CITY OF ALBUQUERQUE

October 10, 2018

RE: **Sicily Plaza**
6001 Coors Blvd NW
Request for Certificate of Occupancy - Permanent
Hydrology Final Inspection – Not Approved
Engineer's Stamp Date 12/13/17 (C16D006LL)
Certification Dated: 10/5/18

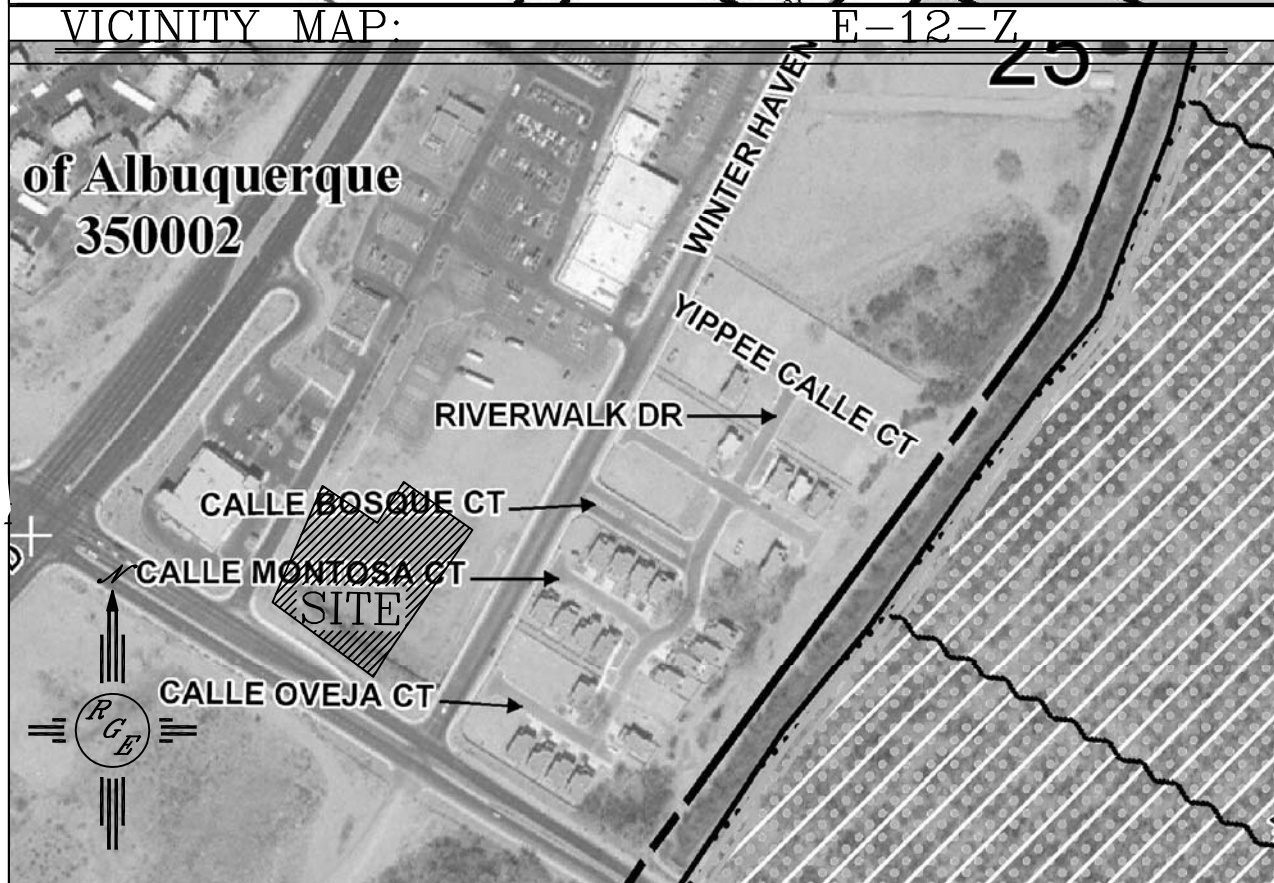
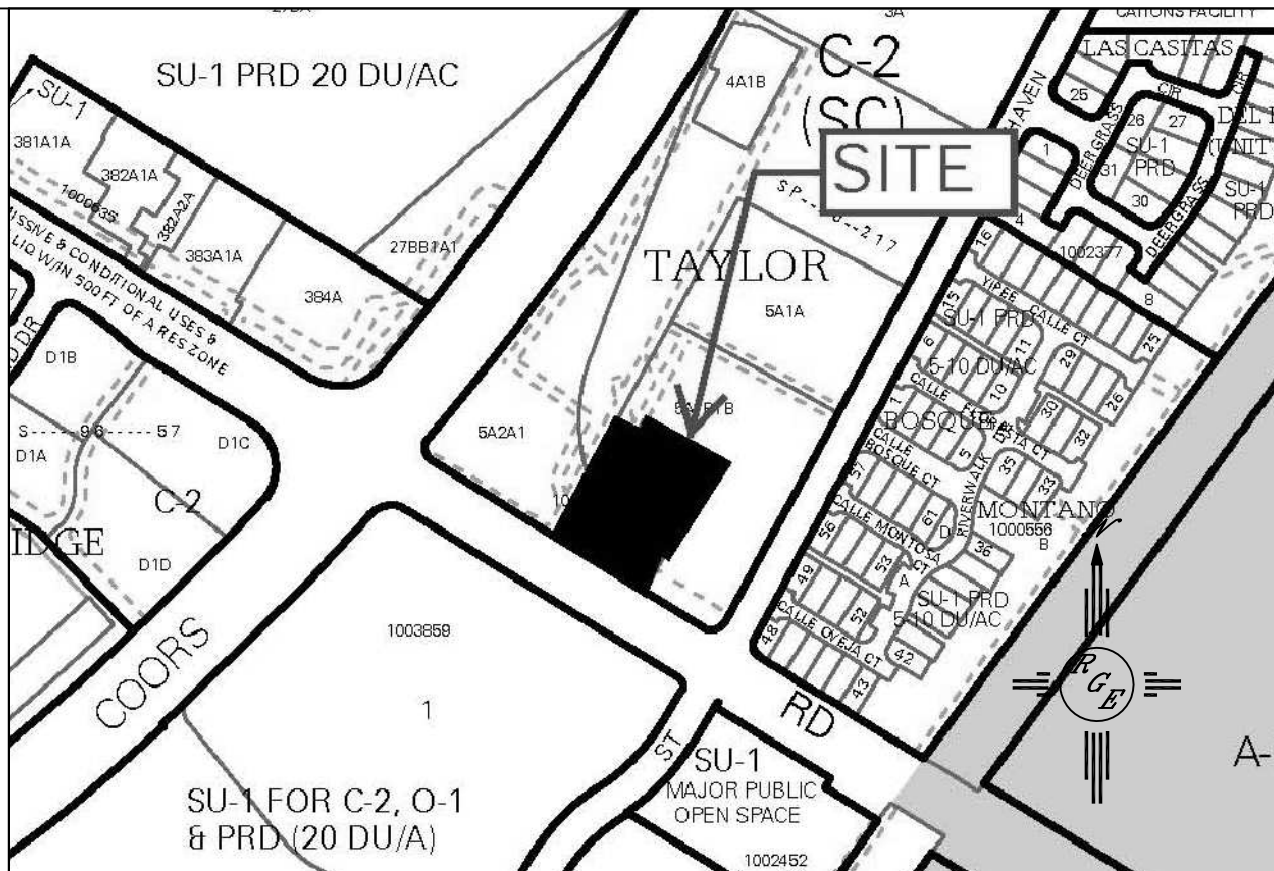
1. The Drainage Covenant will need to be recorded; provide a copy of the Bernalillo County Recorded Drainage Covenant.
2. Include as-built elevations for the bottom of the existing and new ponds with the Drainage Certification; the new bottom of the large pond needs to be surveyed.
3. A digital (.pdf) submittal, emailed to PLNDRS@cabq.gov is required.
4. The underlying grading plan is illegible; provide the certification on a legible version of the plan.
5. The 629cf first flush pond needs to be constructed per plan including excavation to the proper depth and volume. The as-built condition of the pond needs to match the contours provided on the grading plan and be supported with new survey data.
